November 17, 2022

Gareth Reece  
Senior Plans Examiner  
City of Mercer Island Community Planning and Development

RE: Permit 2109-150 SUB2 Correction Comment Responses  
Site Address: 9611 SE 72<sup>nd</sup> Street

SH2.1

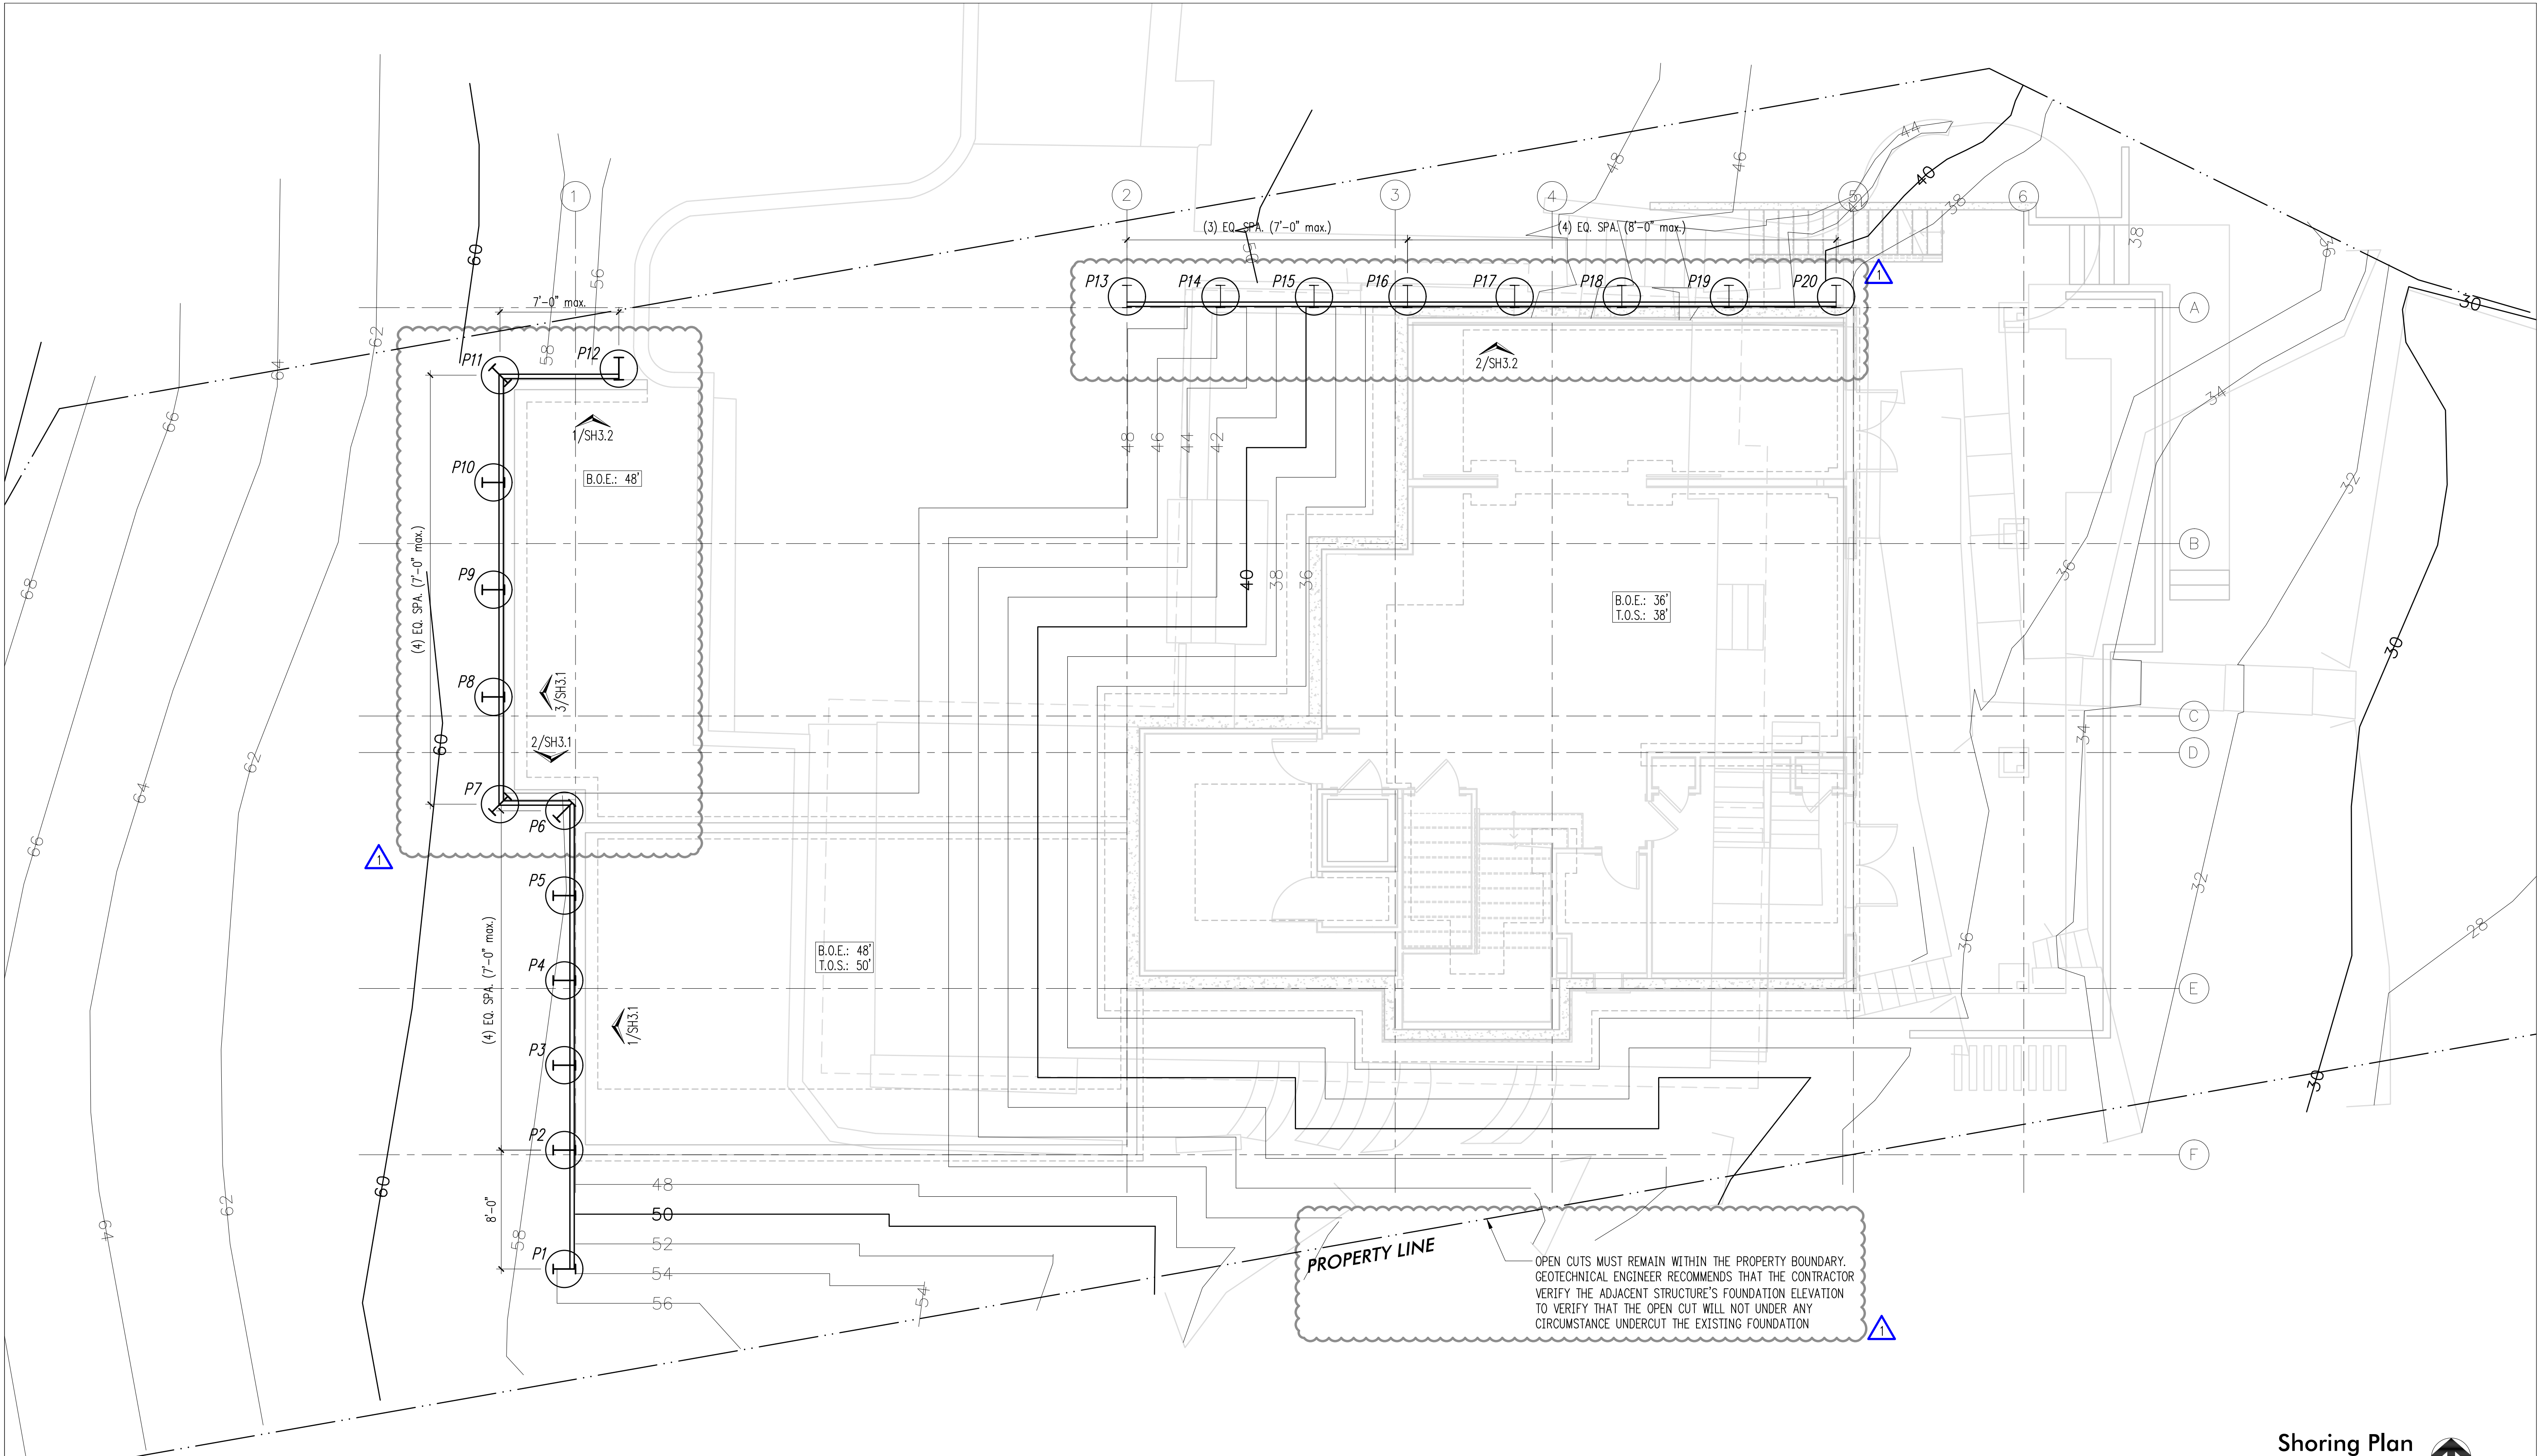
4. Page 3 of the January 6, 2022, PanGeo addendum letter indicates that 2 or 3 soldier piles should be added to the south side of the excavation for the garage. We do not find this incorporated into the design; see Sheet SH2.1.

**Response:** Per email correspondence with Michele Lorilla on 05/11/22 we noted discrepancy between the 01/06/22 addendum and coordination that followed with the geotechnical and

structural engineers. We have confirmed with PanGeo that shoring is not required on the south side of the subject site. Please refer to the submitted addendum and site sections on Sheet A101 showing that a 1H:1V temporary cut slope can be achieved within the property boundary of the subject site. Michele Lorilla noted via email on 05/24/22 that this resolves the correction comment.

Foundation Plan

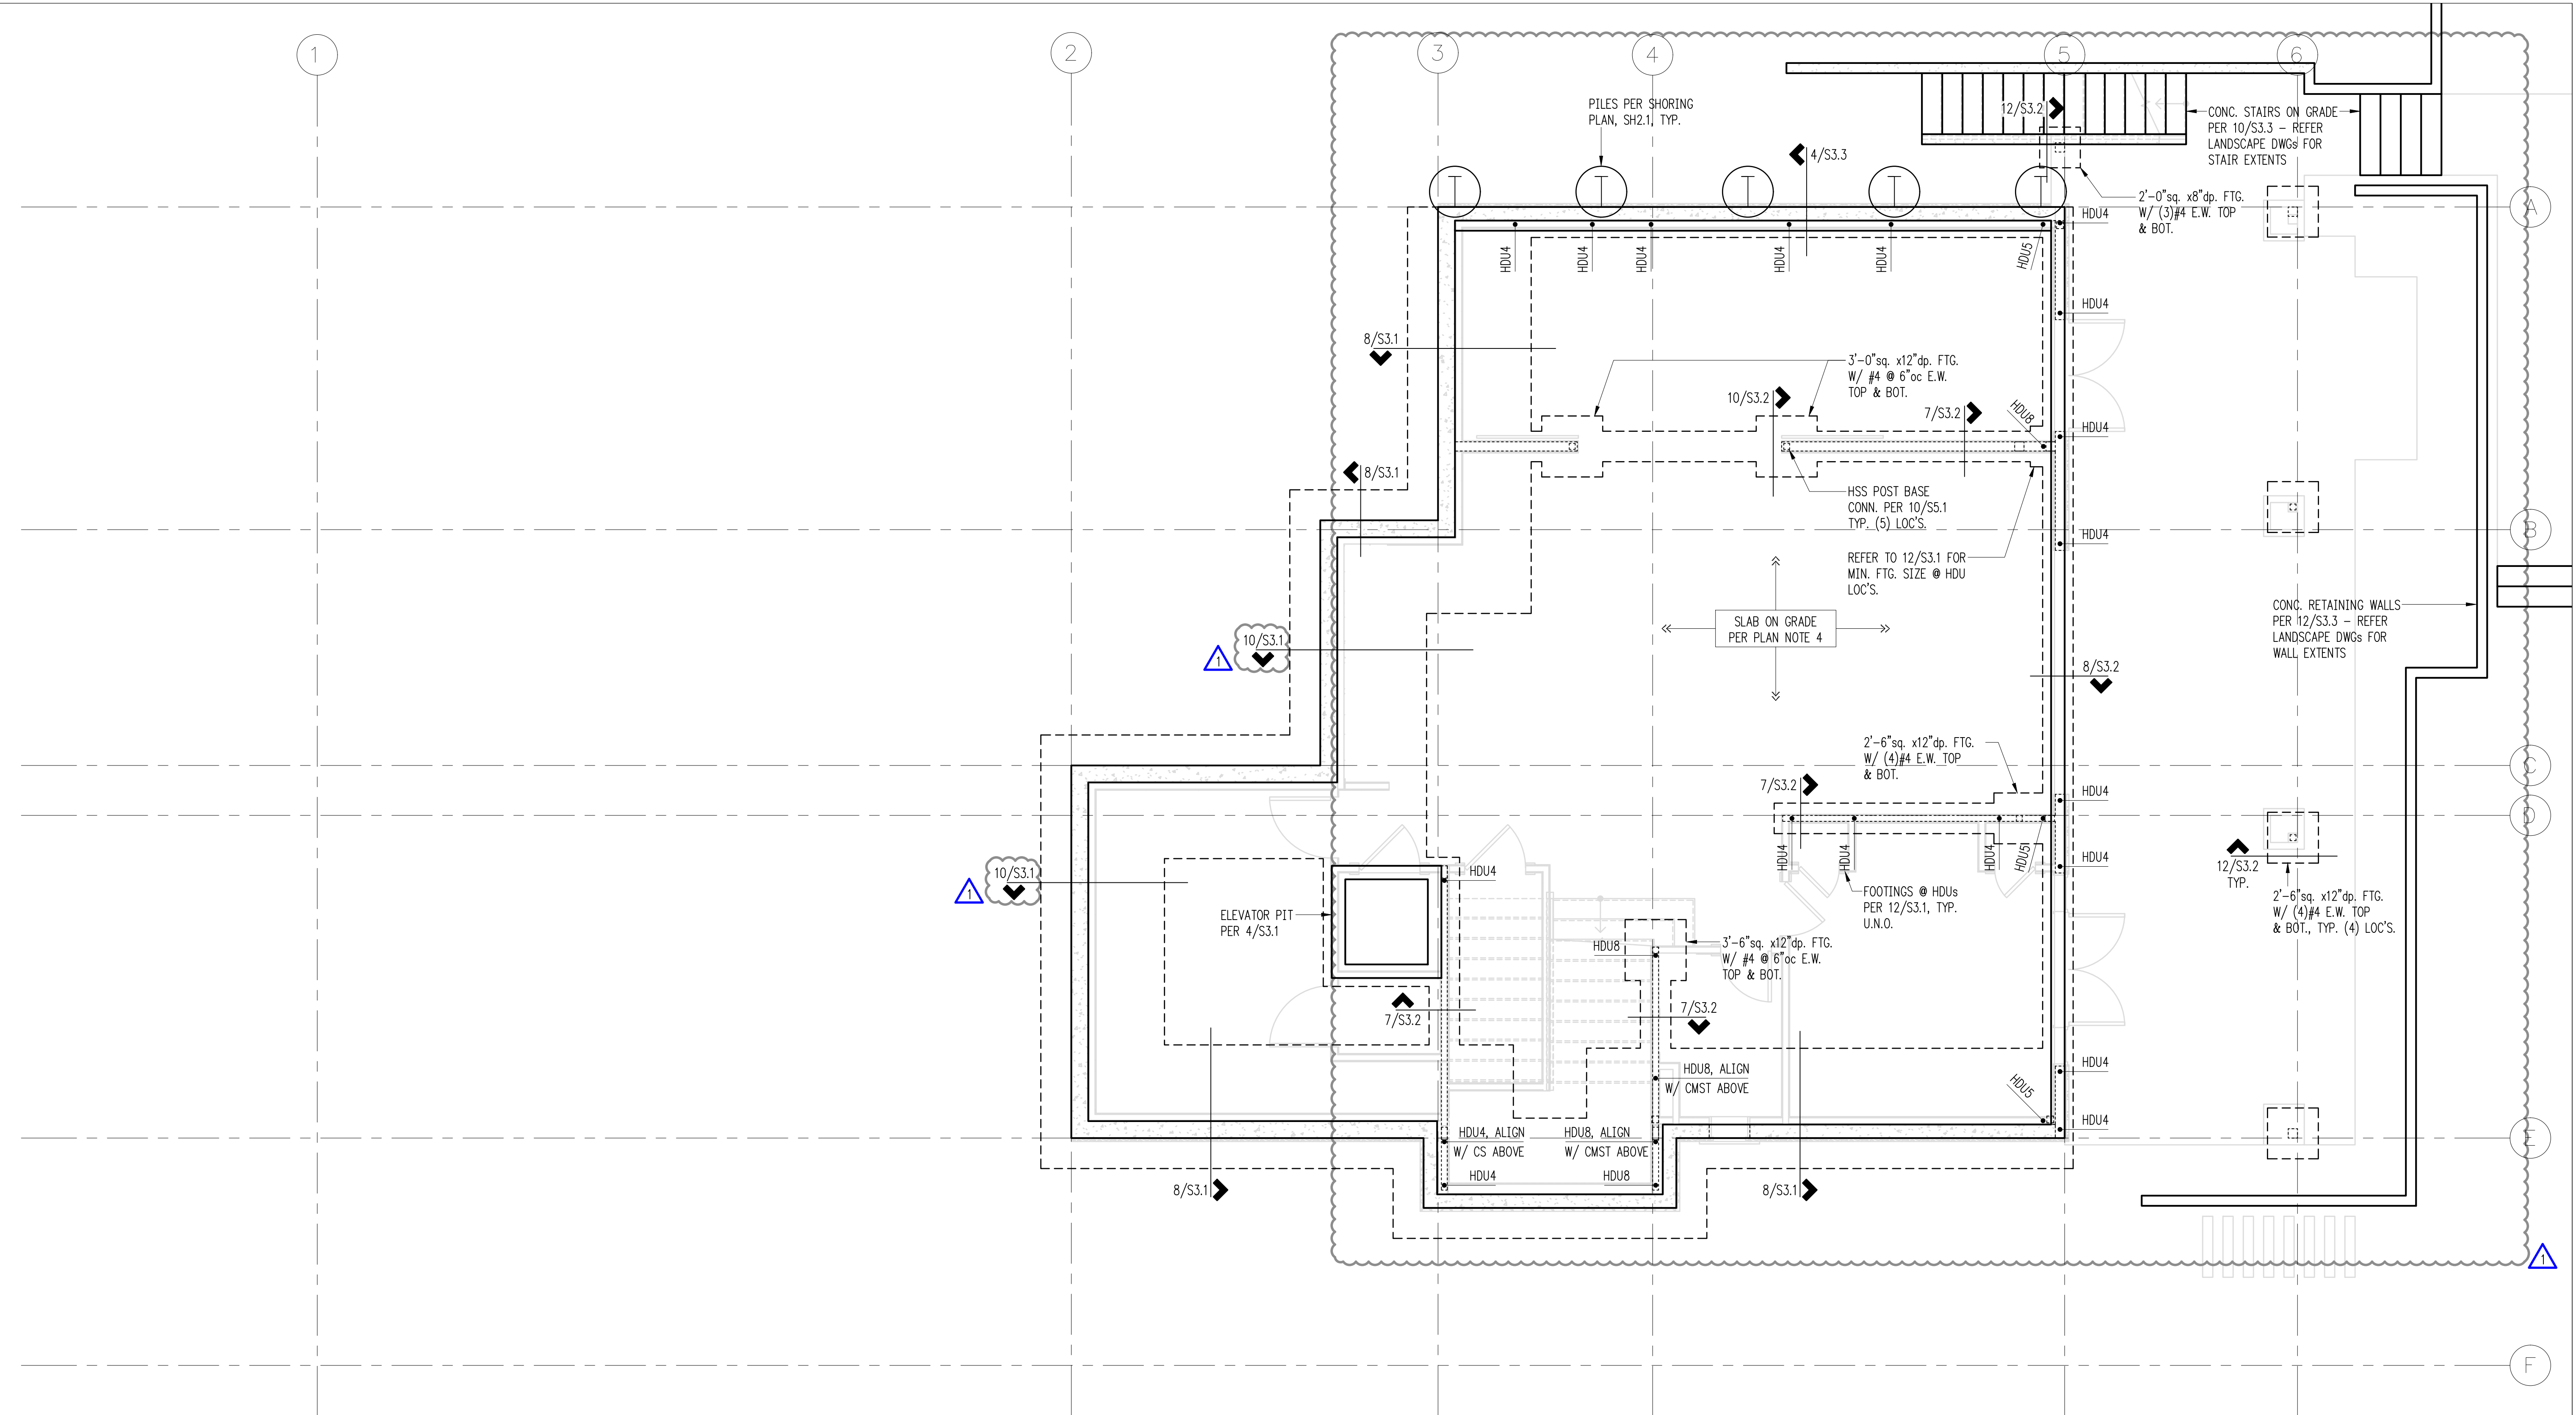
15. The north end of the shear wall along Grid 4 requires an HDU11 holdown per page 7 of the original calculations. Only an HDU5 (now an HDU8 Holdown) is called out on the Foundation Plan, Sheet S2.1. We did not receive updated calculations as referenced in your response letter so our comment remains.

**Response:** Please see calculations provided.
